Application No: M/53/26/HH
Site Address: Seaforth 6 Old Point Middleton-on-sea PO22 7RY
Description of works: Single storey side/rear extensions, first floor side extensions with rear balconies and alterations to fenestration, following demolition of existing conservatory.

Thank you for your internet representation made on 10th September 2026 which has been recorded as support with the comments as follows:

New Multi Coloured Tile Hanging

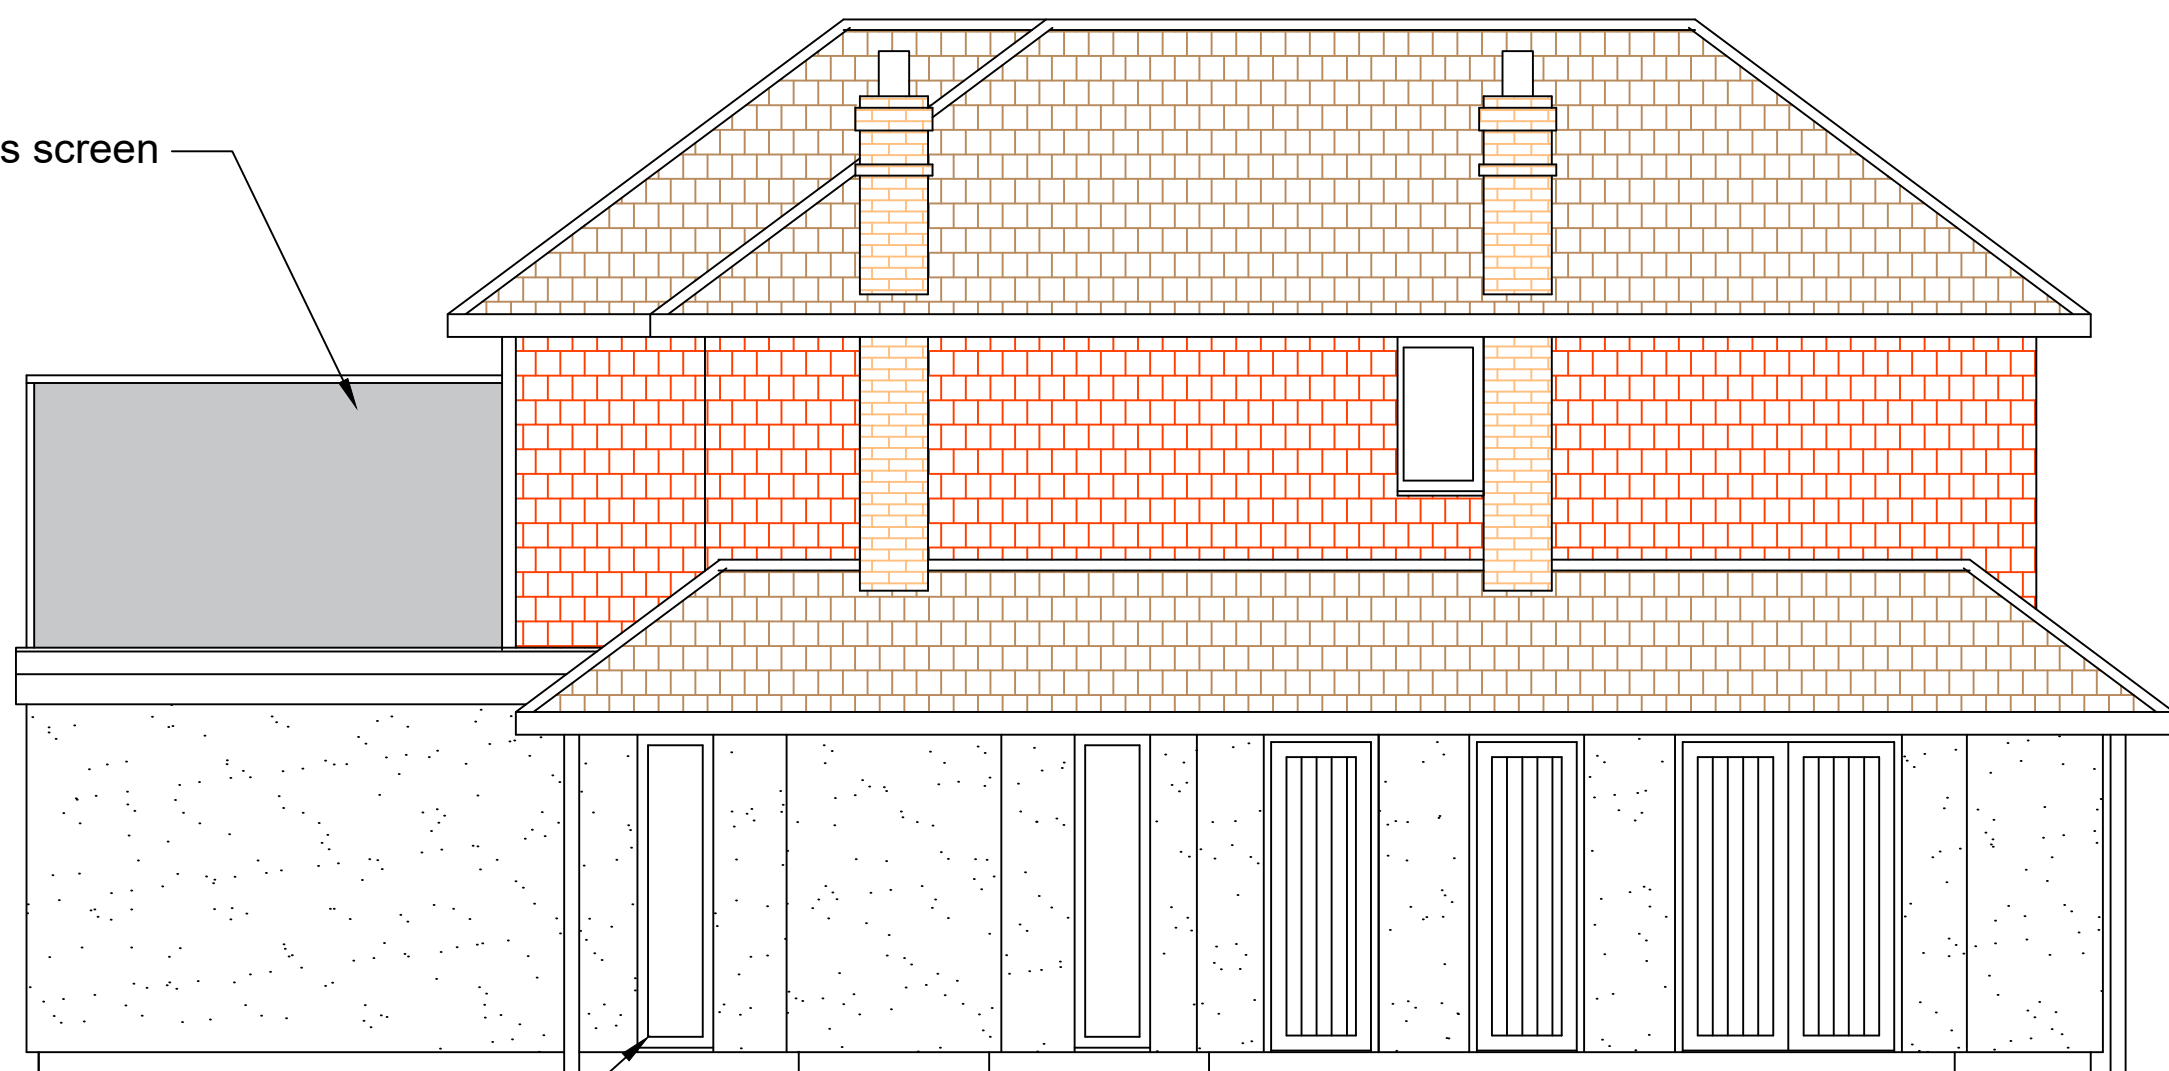
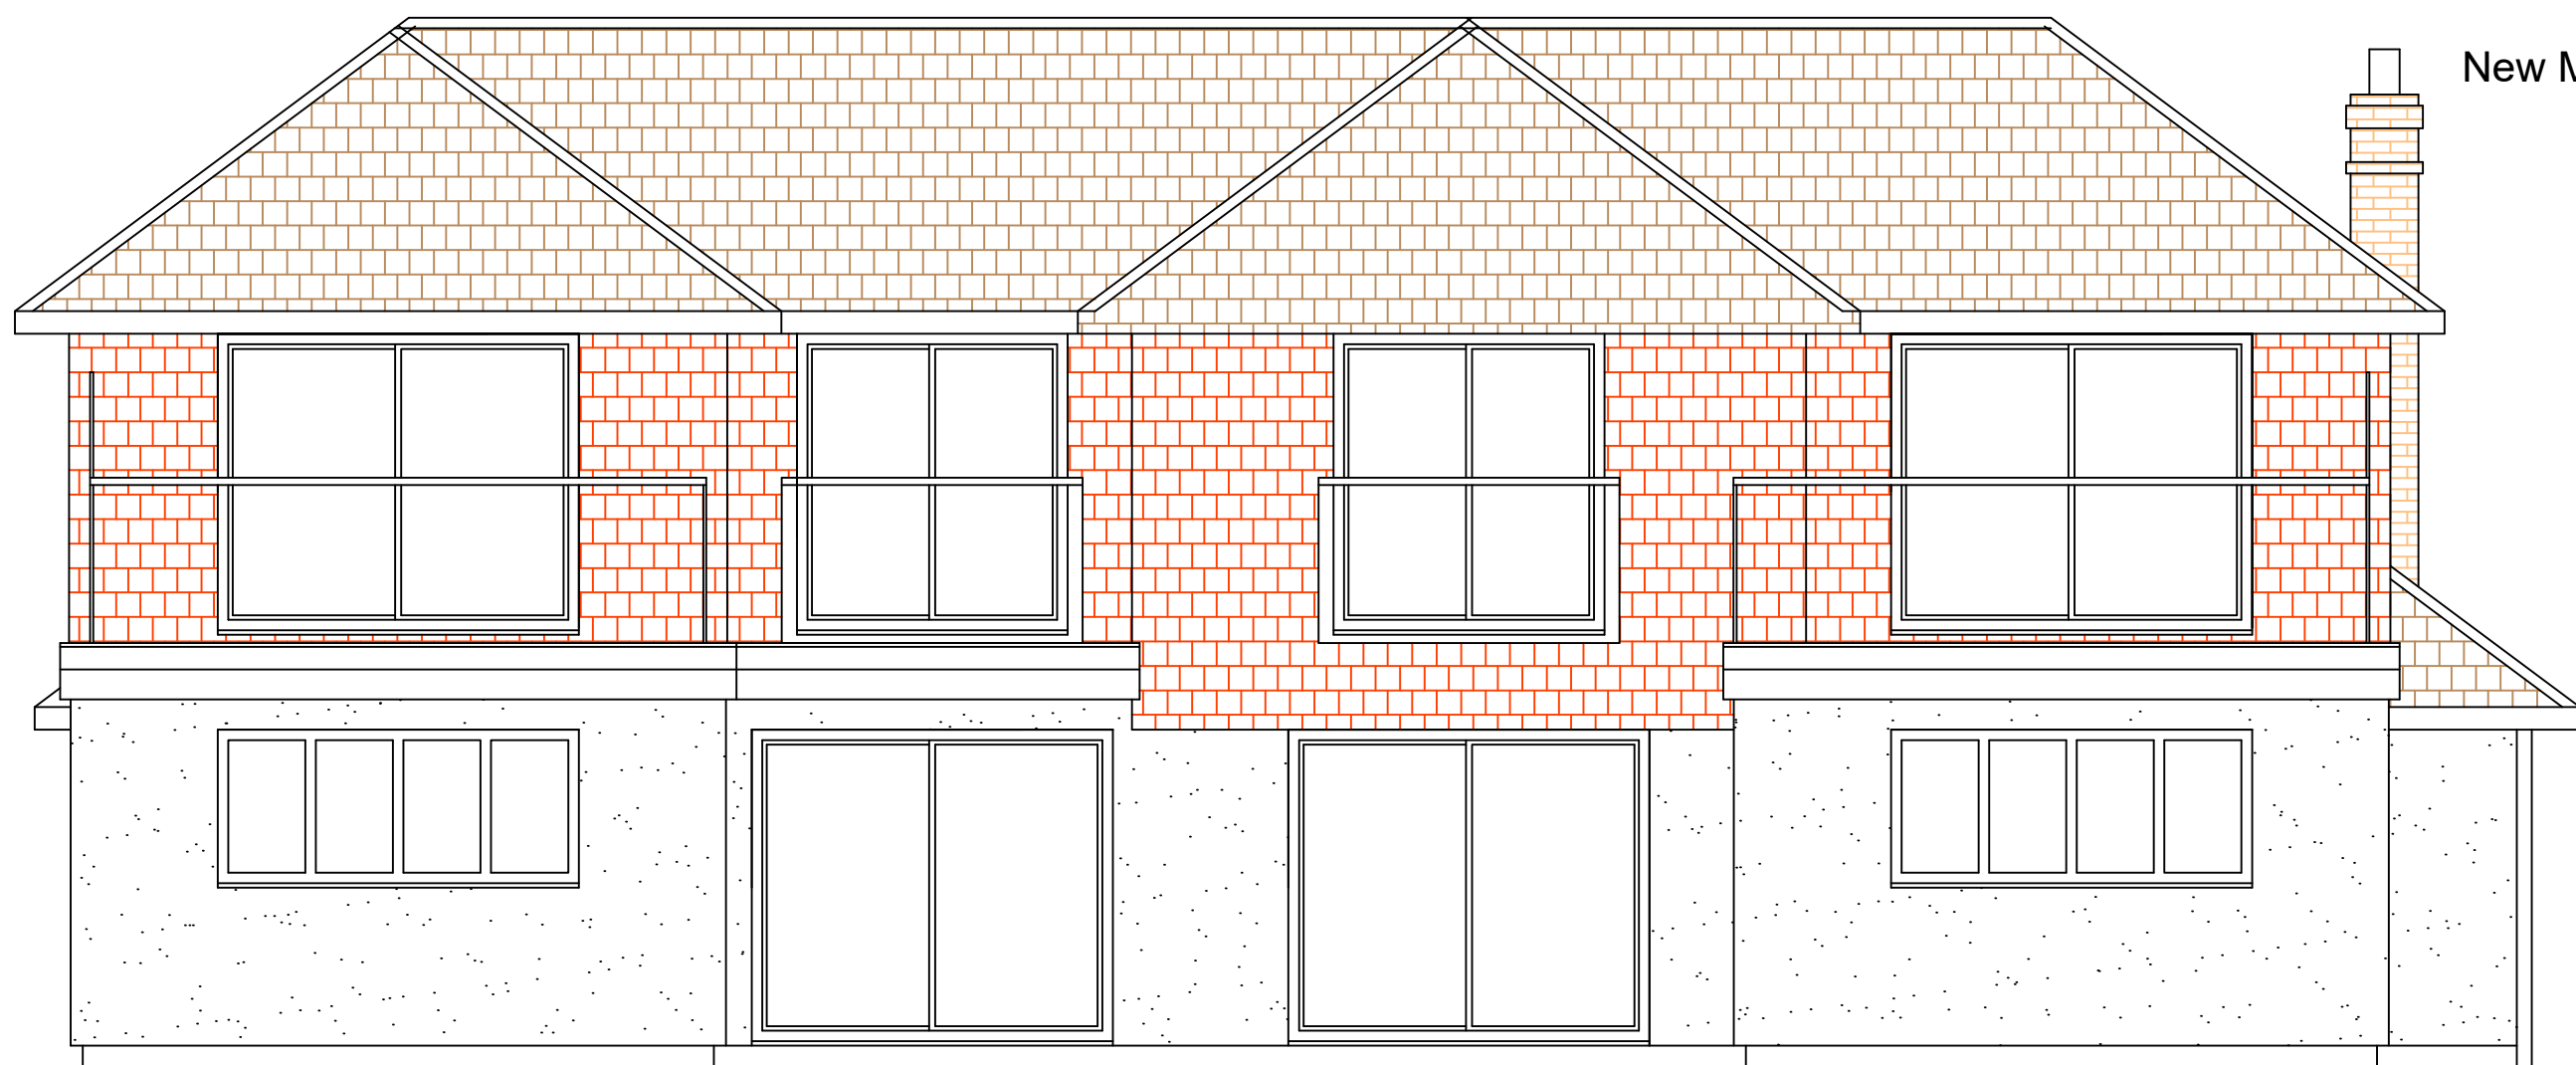
We would ask that the "multi- coloured" tiles are in keeping with the Middleton design statement and or consistent with traditional Sussex character
